**P2288**

**ADDENDUM ENVIRONMENTAL IMPACT ASSESSMENT REPORT  
EXECUTIVE SUMMARY OF AMMENDMENTS**

**RIVERINE COMMUNITY PARK**

**APRIL 2022**

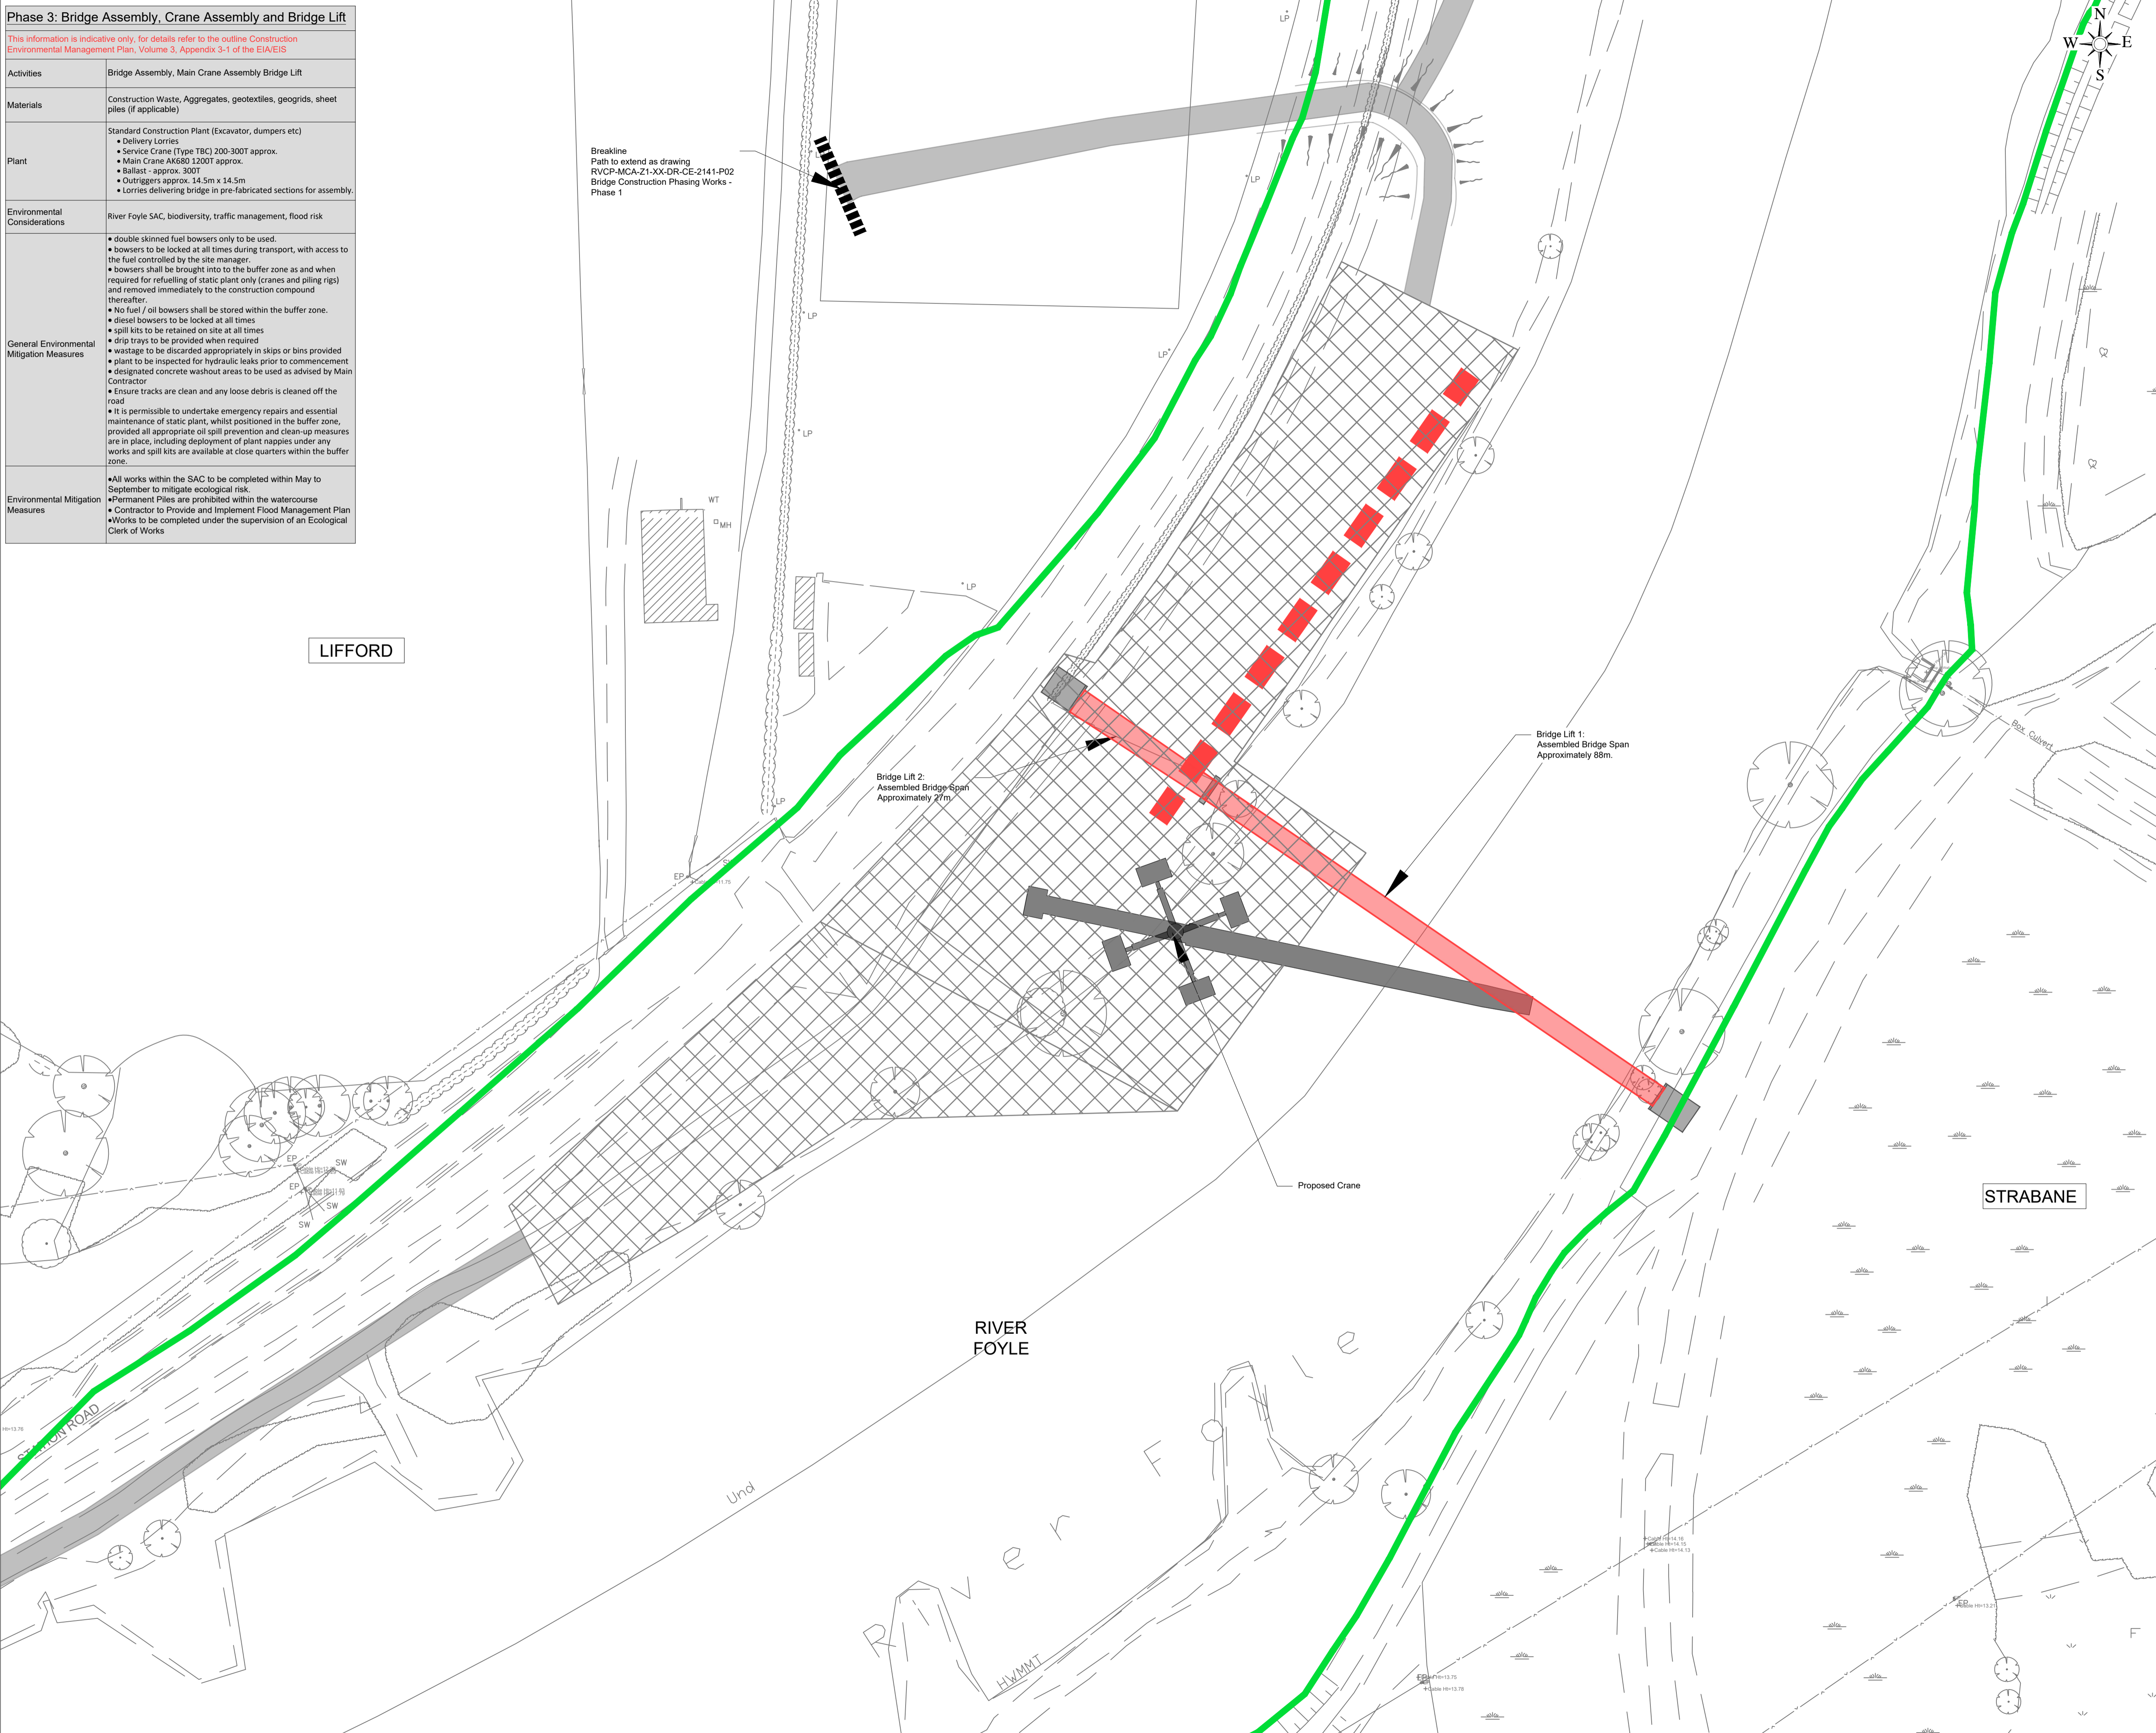
2. *Provide a detailed and comprehensive description of the construction works for each element of the development proposed on the riverbank and extending into the River Foyle to include the temporary crane pad, slip way and jetty, fishing pods and approaches. The information shall include details of the site preparation, construction methodology, sequencing of works, removal of temporary structures following completion, details of the types of machinery, composition and source of the materials to be used. Precise details of the mitigation measures proposed shall be submitted, that will be employed to prevent sediment and other pollutants from entering the water course during the construction stage. This information shall be fully integrated in the OCEMP and NIS.*

In response to the prohibition of permanent in-channel works, this bridge installation technique considers two single span lifts;

- Lift one – of single span length c30m, between the proposed abutment and the intermediate pier (both located on the Lifford landside of the River Foyle)
- Lift two - of single span length circa 90m and weight circa 100T, to achieve a clear span over the River Foyle, between the intermediate pier (Lifford landside) and the proposed abutment (Strabane landside).

To facilitate the single span lift of c90m and c100T, a 1200T structural crane such as the AK 680 1200T will be required. This is a very large crane which will require an additional service crane, somewhere in the region of 200T to 300T capacity, to assemble the 1200T structural crane and load the required ballast of c300T. The out-rigger centres of the structural crane are expected to be c14.5m x 14.5m with a jib length c85-100m long and a lifting radius of c30-35m.

In consideration of the expected lifting radius of the structural crane, a temporary working platform, extending into the river channel, will be required to facilitate the single span lift of c90m and c100T. This temporary working platform is expected to be designed and constructed in the region of:

- Platform Area: 1000-1500m<sup>2</sup>
- Perimeter Length: 100-150m
- Average Depth: c2-3.5m

The Contractor's detailed installation sequence of the temporary working platform, extending into the river channel, should give due consideration to the following:

1. Install of basal geotextile separation membrane and install rock armour sequentially from upstream side to create access and working area of temporary platform. The geotextile separation membrane will be required to provide segregation of the existing environment and temporary environment and to act as a barrier to lateral sedimentation migration toward the river.

7. Completion of pile testing.
  8. Install of temporary, cast in-situ, reinforced concrete crane platform over piles. Formwork with geotextile separation membrane to be provided and remain in-situ until concrete cured, to act as a barrier to the river channel.

9. Placement of structural crane into lifting location, ensuring minimum edge distance maintained between jacklegs and edge of platform.
  10. Completion of bridge lift.

11. Removal of the temporary platform by digging around the CFA piles and break down to c500mm below bed level and subsequent removal of temporary working platform in reverse order to installation, i.e., downstream end first. Removal works to utilise low vibration methods (e.g., the use rock hammers will not be permitted) and will require the immediate loading and off-site removal of fill (no temporary storage of removed materials will be permitted). However, where appropriate, there should be due consideration to the re-use and permanent allocation of the rock armour and fill materials for construction of the proposed slipway.
